RE: Simmons Short Plat (SP-11-00008)

The Kittitas County Community Development Services Department has determined that the Simmons Short Plat (SP-11-00008) is a complete application and hereby grants *conditional preliminary approval* subject to the following conditions:

SUBJECT: Simmons Short Plat SP-11-00008

RE: Simmons Short Plat SP-11-00008

KITITAS COUNTY SHORT PLAT

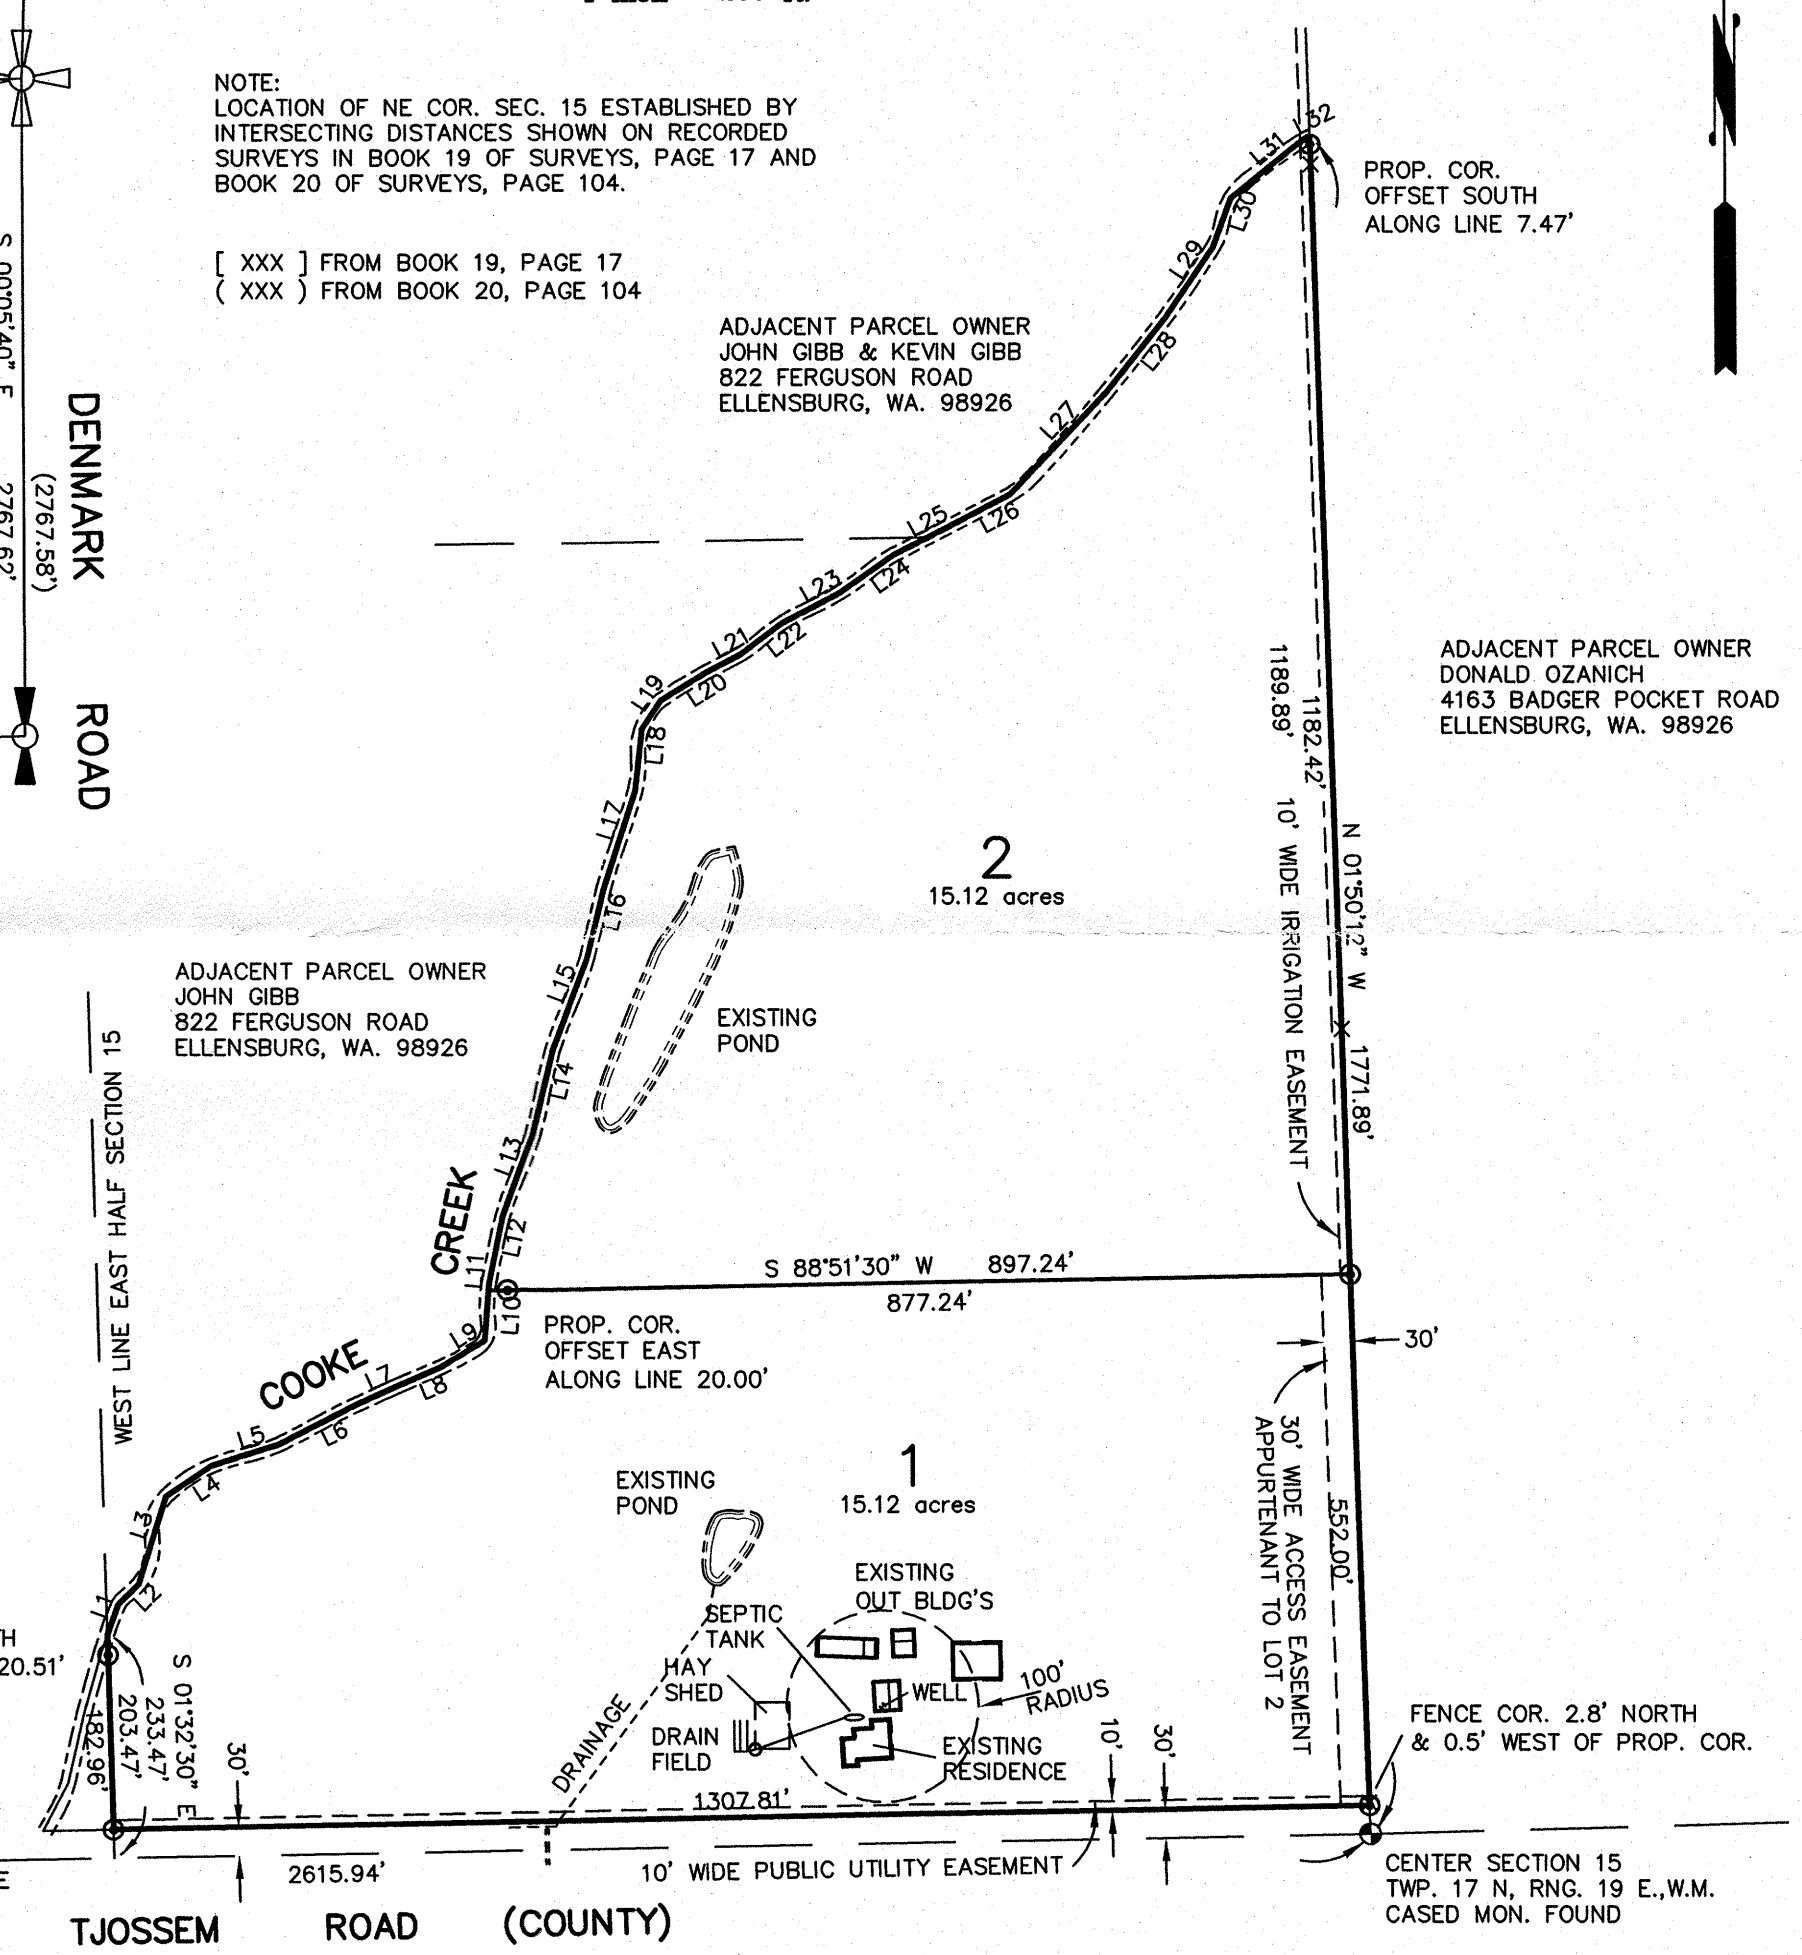
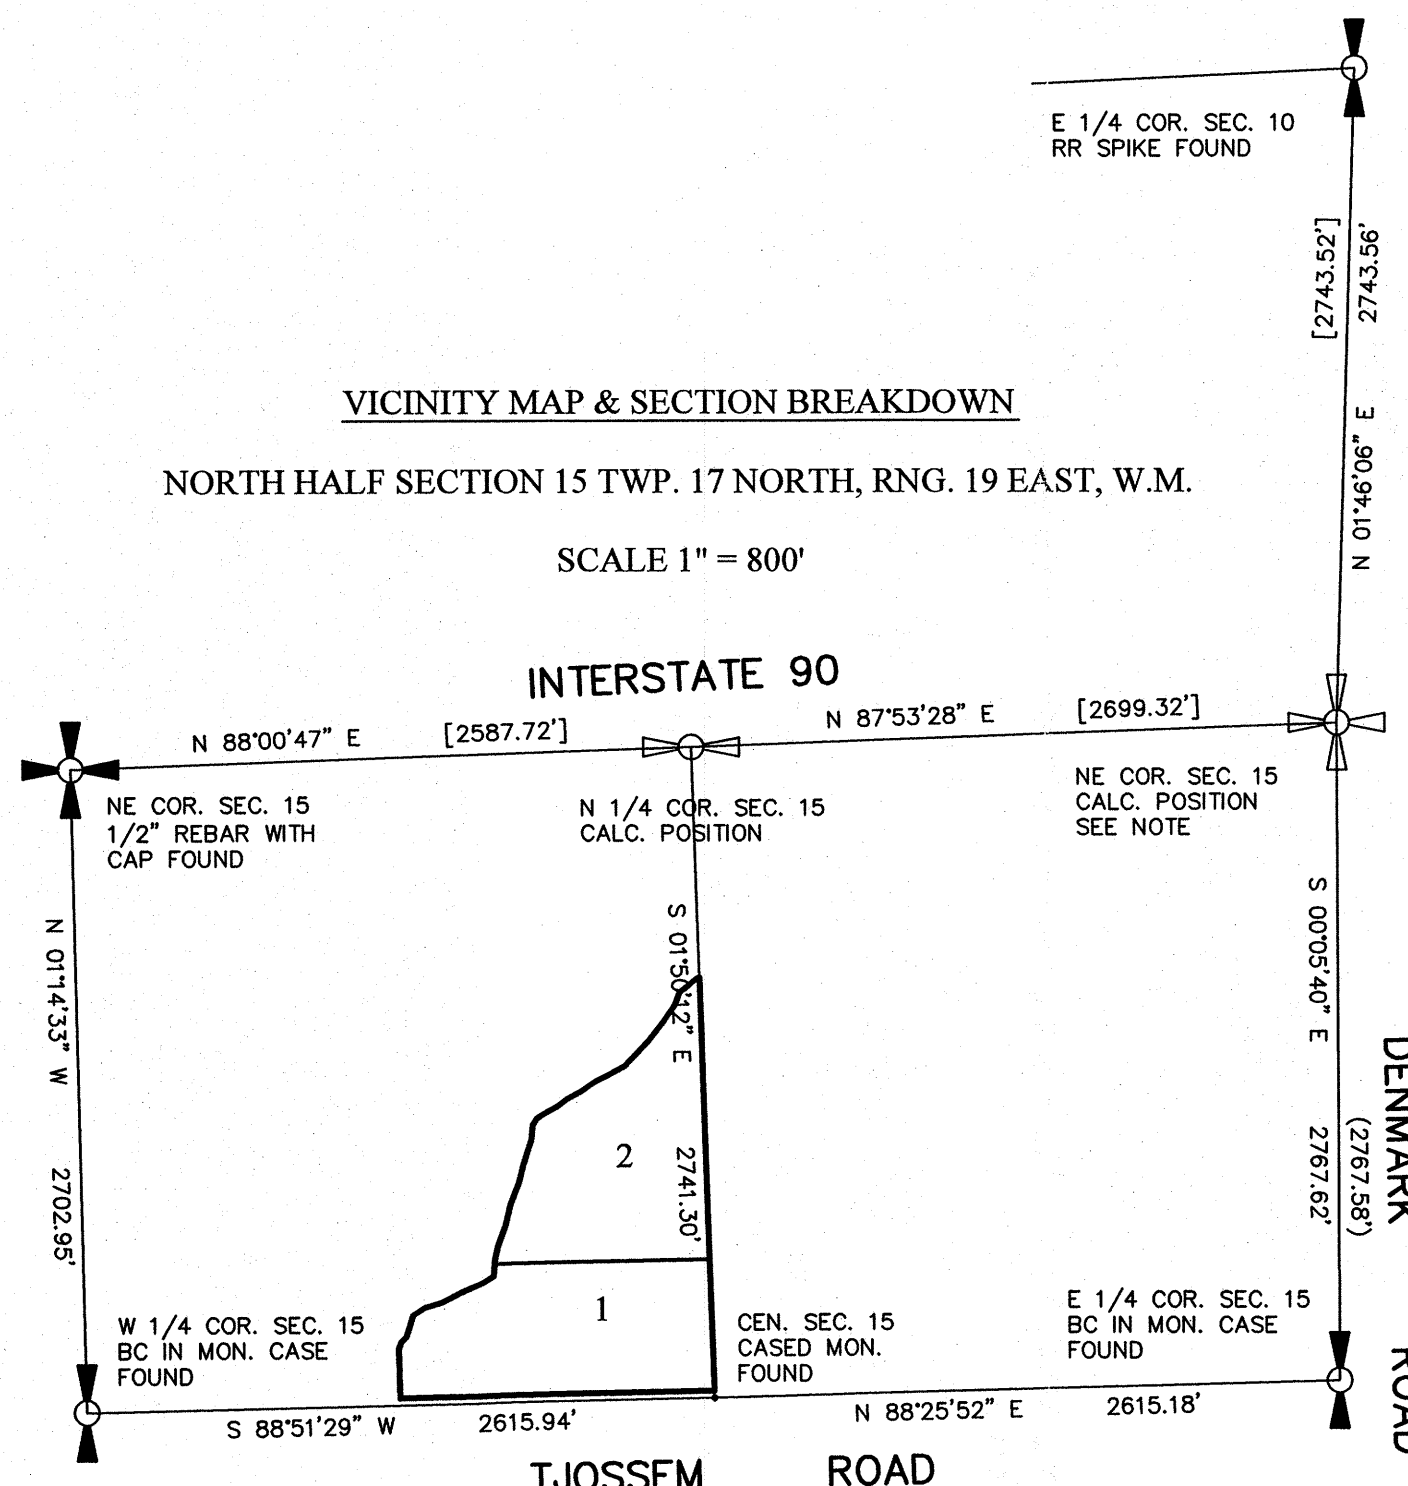
Tjossem Road is classified as a Major Collector and has an access spacing requirement of 1000'. The proposed access to Lot 2 is currently an agricultural access and does not meet the spacing requirement for a change of use to residential. The applicant shall either use one of the two approaches at the existing residence on Lot 1 as access to Lot 2, or apply for a variance from the access spacing requirement. The applicant can contact me at 509-962-7051 to discuss these options.
